COMMUNITY DEVELOPMENT DEPARTMENT
80 Columbia Avenue ♦ Marysville, WA 98270 ♦ (360) 363-8100

August 19, 2022

Re: Soper Hill Station – *Technical Review 1*
PA22030

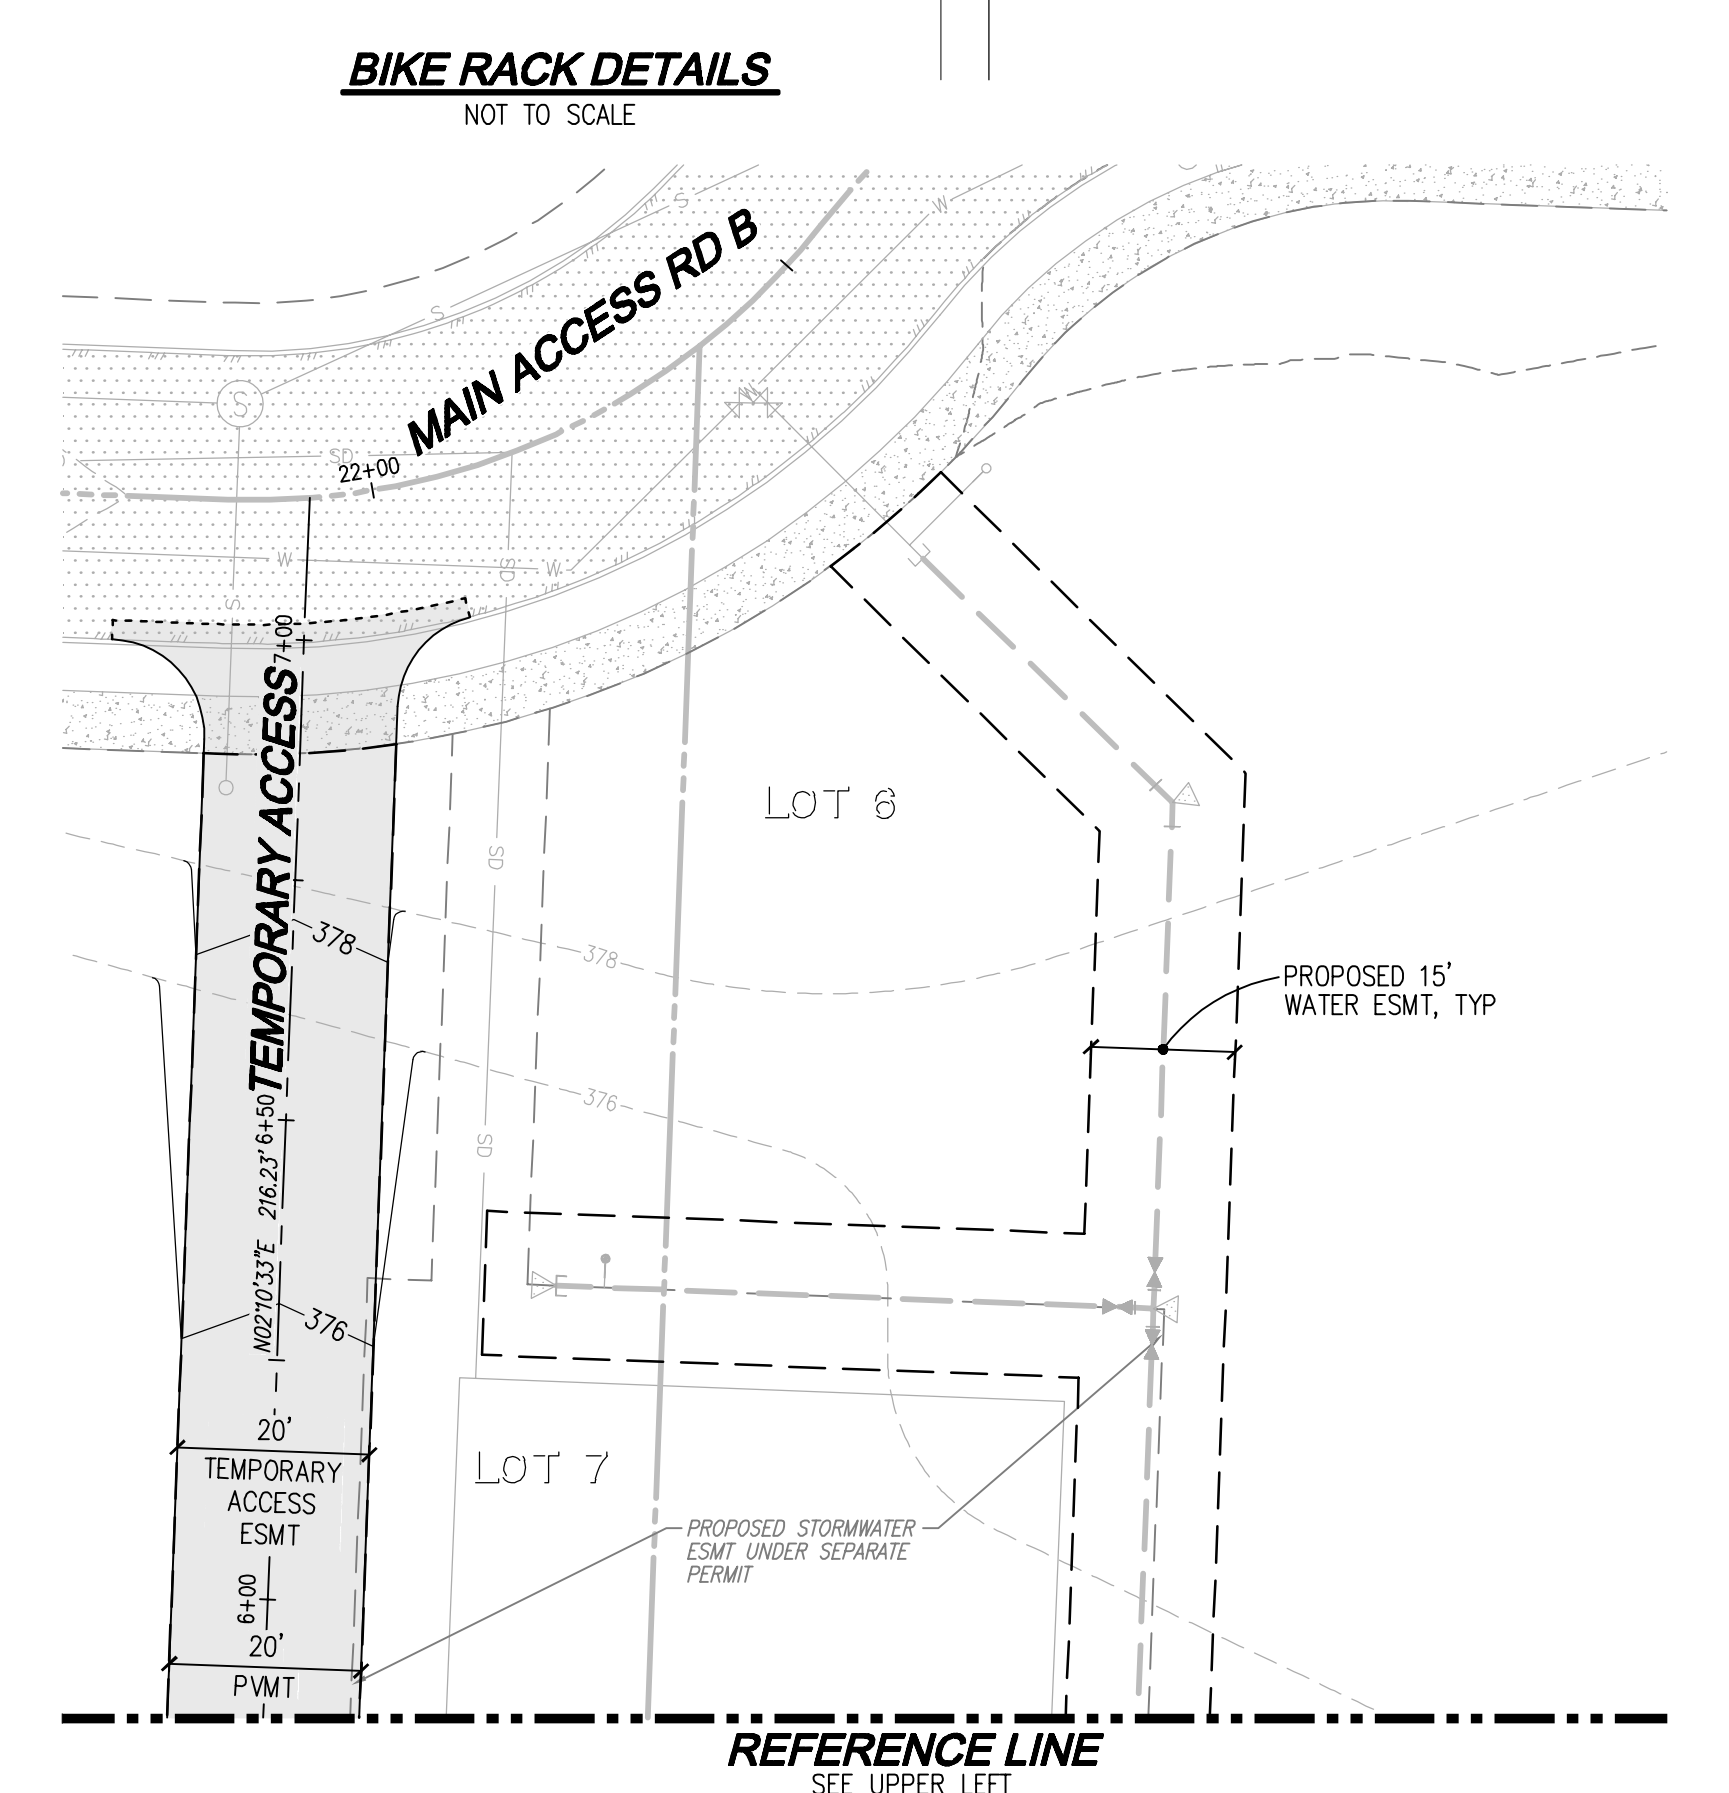
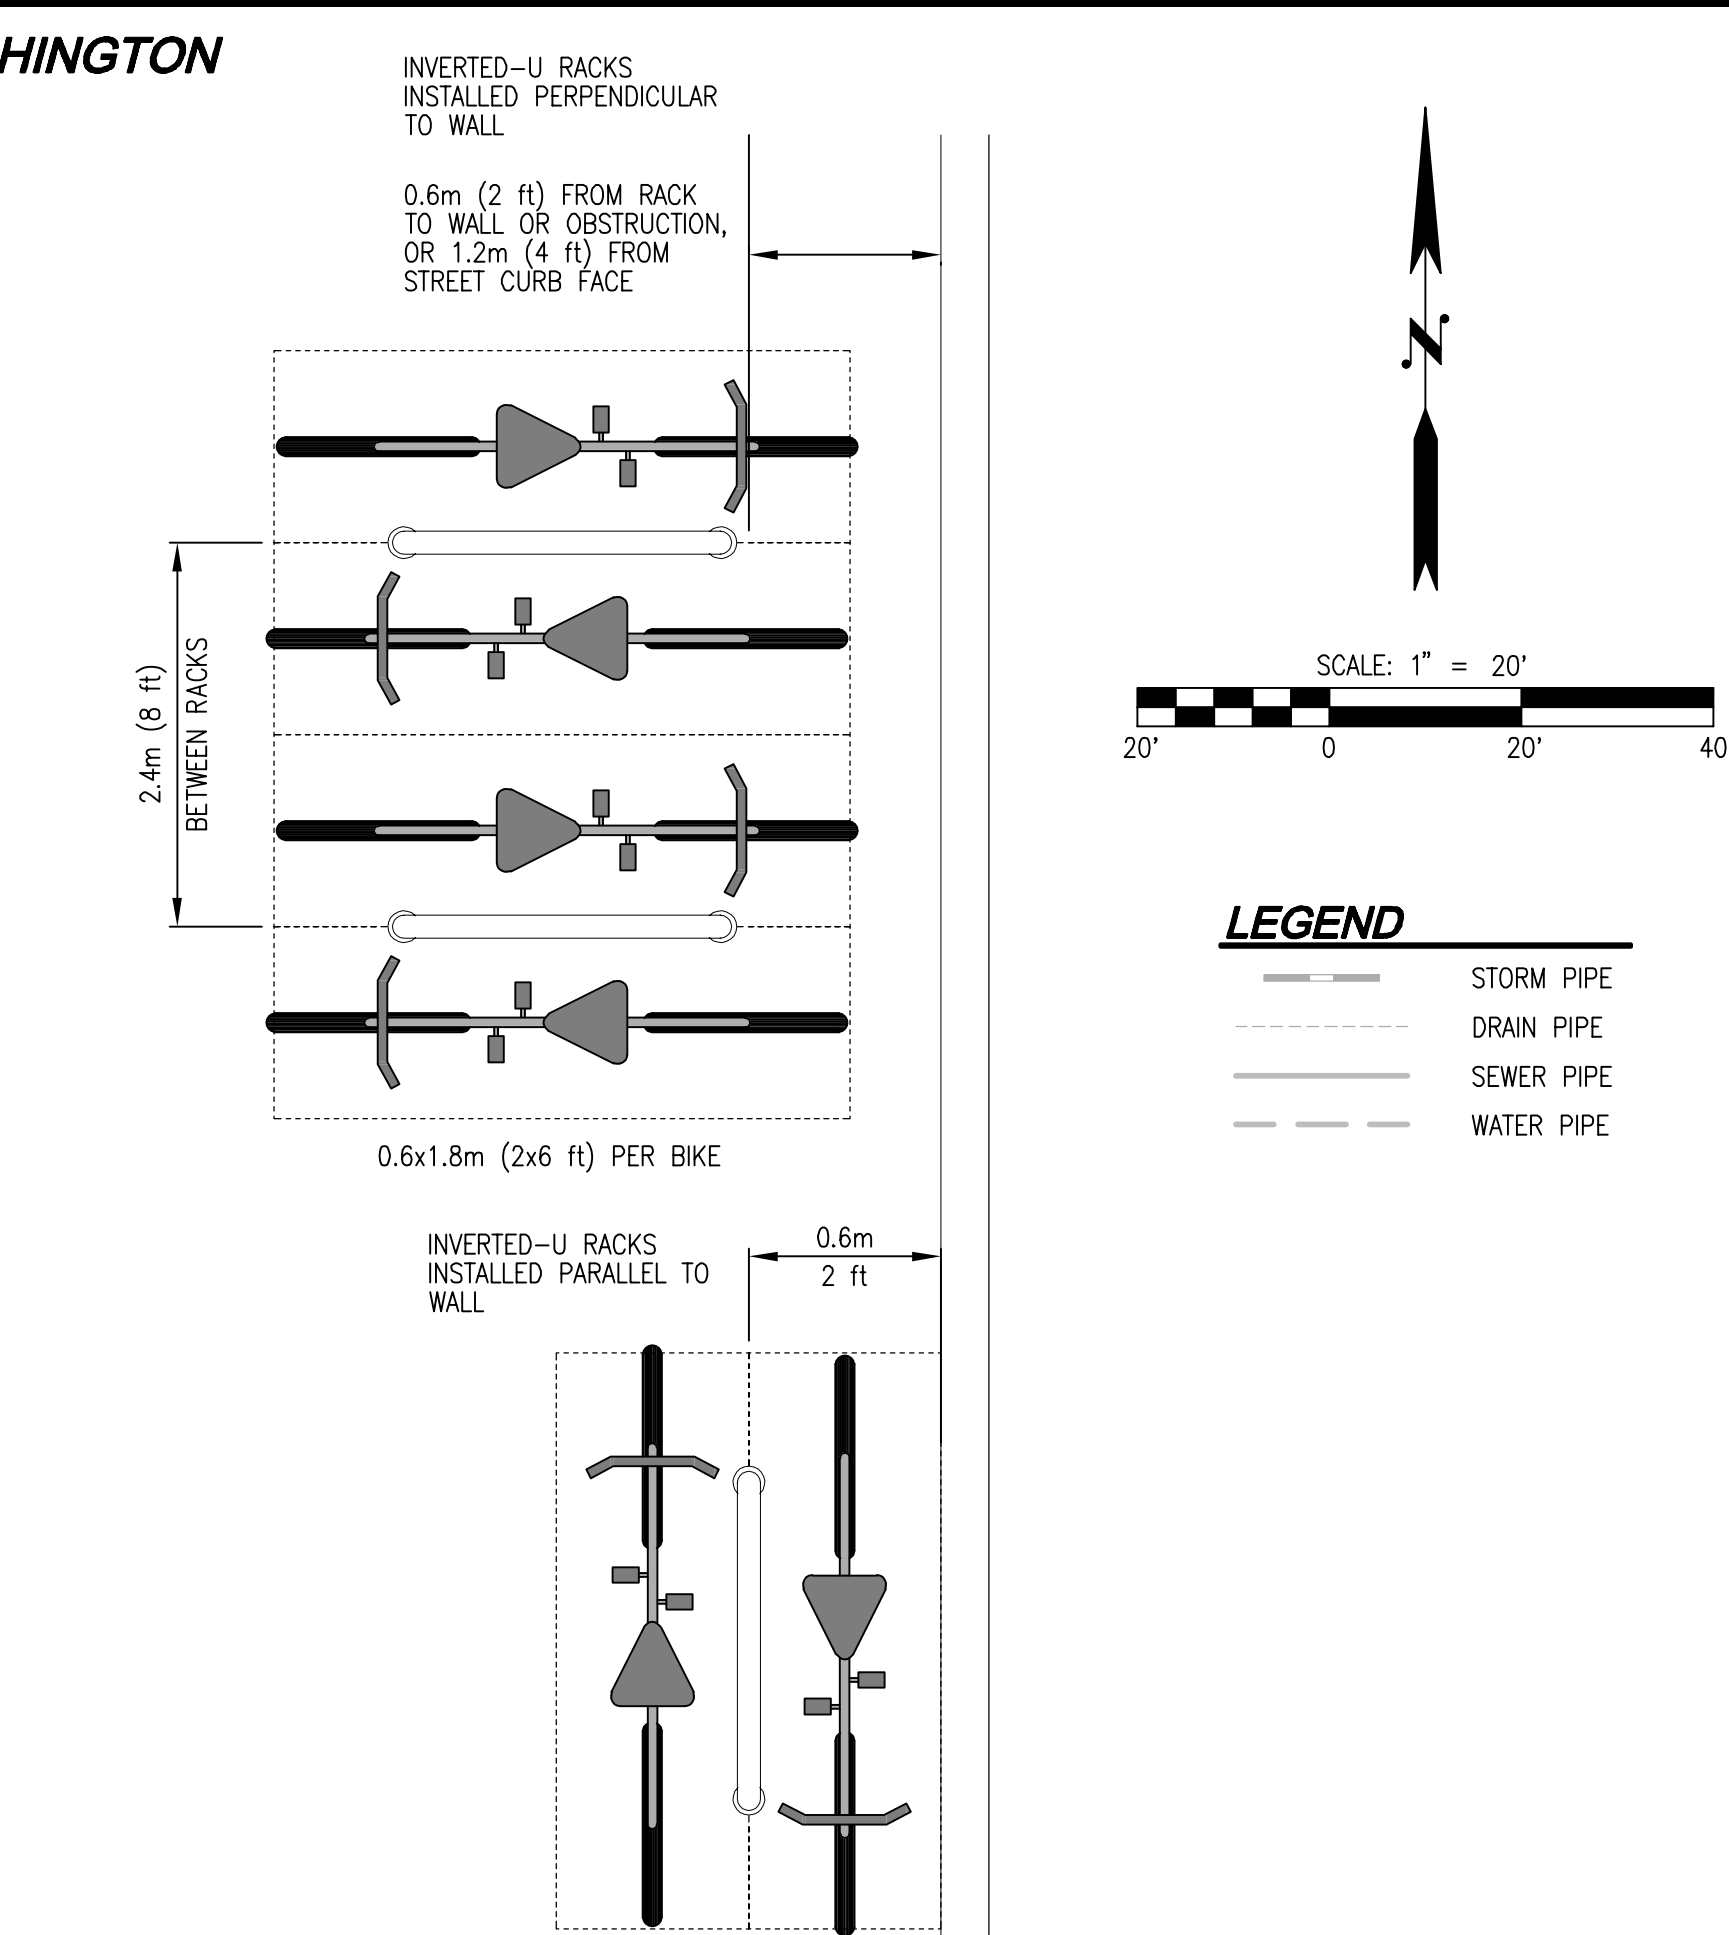
4. Amend Sheet SP-02, as follows:
 - a. Provide impervious surface calculations;
 - b. Provide an auto-turn exhibit with the formal land use application to ensure adequate circulation for both patrons and fueling trucks. Additionally, the applicant shall be required to demonstrate how a fueling truck can safely navigate through the White Barn Center;

- c. Add a minimum 5’ pedestrian pathway from the proposed open space area to Lot 1;
 - d. Provide a pedestrian connection from Lot 2 across the Main Access Drive to Lot 3. Consider potential development of Lots 3 & 4 for location of pedestrian connection;

- e. Amend the parking calculations to include building SF and math for calculating the required number of spaces, similar to the project narrative;
 - f. It appears that some of the proposed parking stalls measure 8’ in width. 8.5’ minimum required;

- g. B.4.1.a. requires a side and rear setback of 15’. It appears the building is only setback 10’ along the south property line
 - h. F.1.1 requires a 30’ landscaping setback from Soper Hill Road and a 20’ setback is required from Road A when a parking areas and drive aisles are located

adjacent to these roadways. The *Director* may approve and condition reduced planter widths provided the design meets the intent of the standards and guidelines. For example, reduced widths may be allowed provided the landscaped area is supplemented with architectural features that help to define the street edge and maintain visual continuity along the street. Examples could include a decorative low wall made of stone or masonry that is used in conjunction with landscaping, and/or use of a landscaped trellis or architectural columns. For each method, it is important to maintain visibility at eye level (between 3 and 8 feet above the ground) between the street into the parking lot for safety.

- i. F.2.4.a. requires service elements (i.e. solid waste disposal areas) to be located to minimize the negative visual, noise, odor, and physical impacts of the street environment, adjacent (on and off-site) residents or other uses, and pedestrian areas. The proposed location of the solid waste collection area will need to be relocated so that it is not visible upon entry into the site.

- j. A minimum 5' L4 landscape buffer is required at the end of the row of parking on the northeast portion of the parking area.
5. The following comments are related to required building design:
